**Subject:** RE: Attached letter from Kirklees Council regarding application number 2024/91243 at location Land at Nabbs Lane, Slaithwaite, Huddersfield, HD7 5AU

Please arrange for the inclusion of the following conditions:

Proposed Site Plan - 1:100

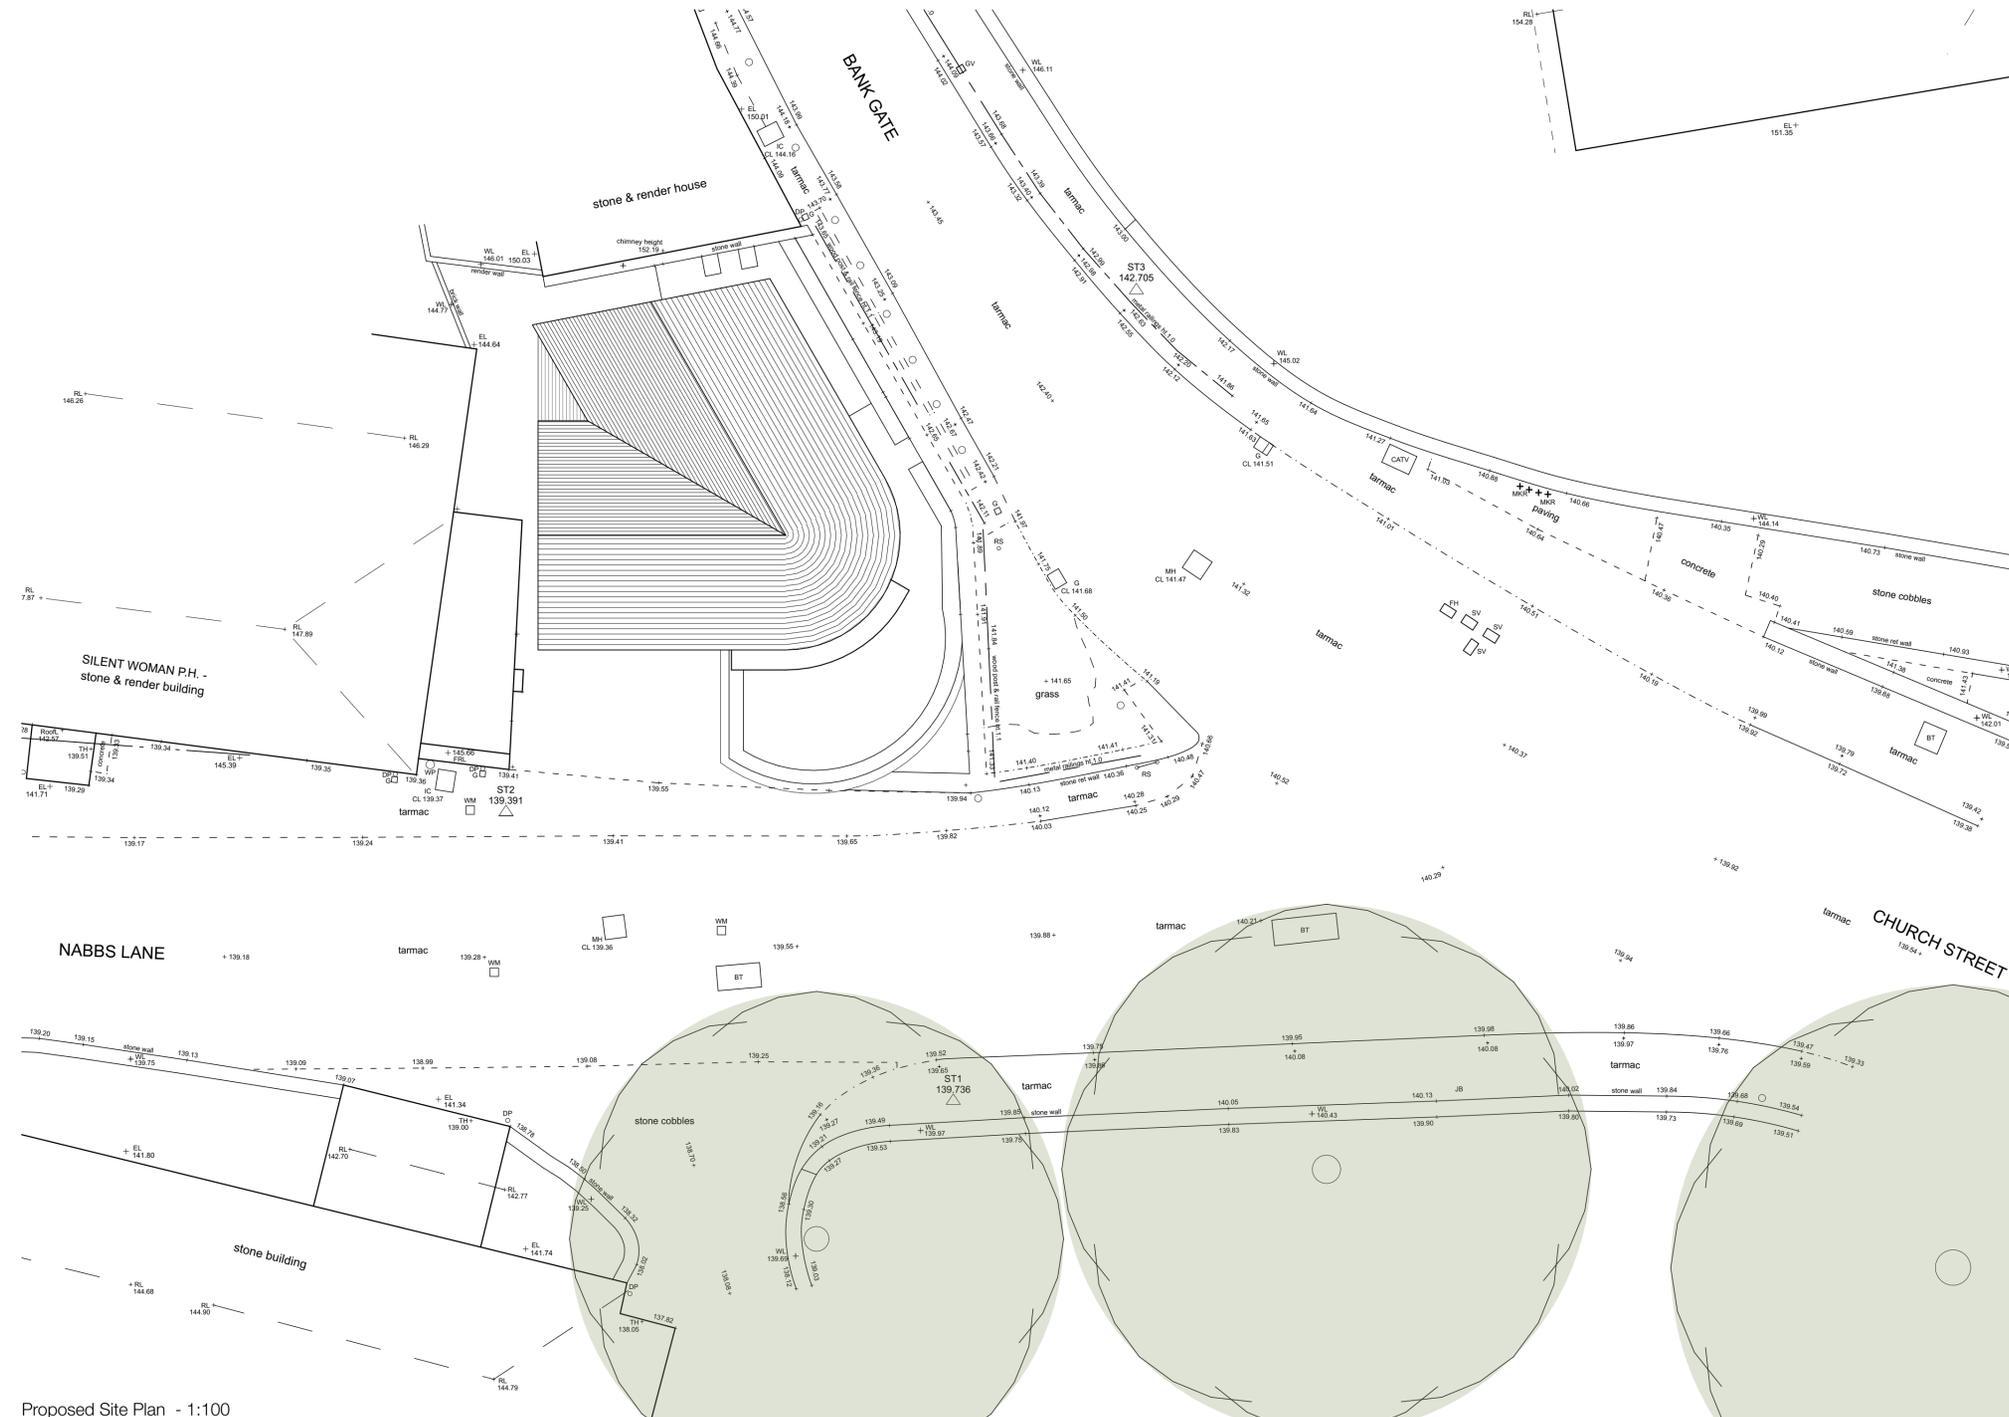
- 1) Before the development commences, the design of proposed retaining walls adjacent to the existing highway including any modification to the existing private retaining wall supporting Bank Gate shall be submitted (via the submission of AIPs) and approved by the Highway Authority in writing. The approved scheme shall be implemented prior to the commencement of the proposed development and thereafter retained during the life of the development.
- 2) An easement strip of not less than 2.0m wide shall be retained between the proposed building and the existing private retaining wall supporting Bank Gate to facilitate access for its future inspection and maintenance, unless if the proposed building wall directly abuts Bank Gate and is designed to accommodate the required highway loading.
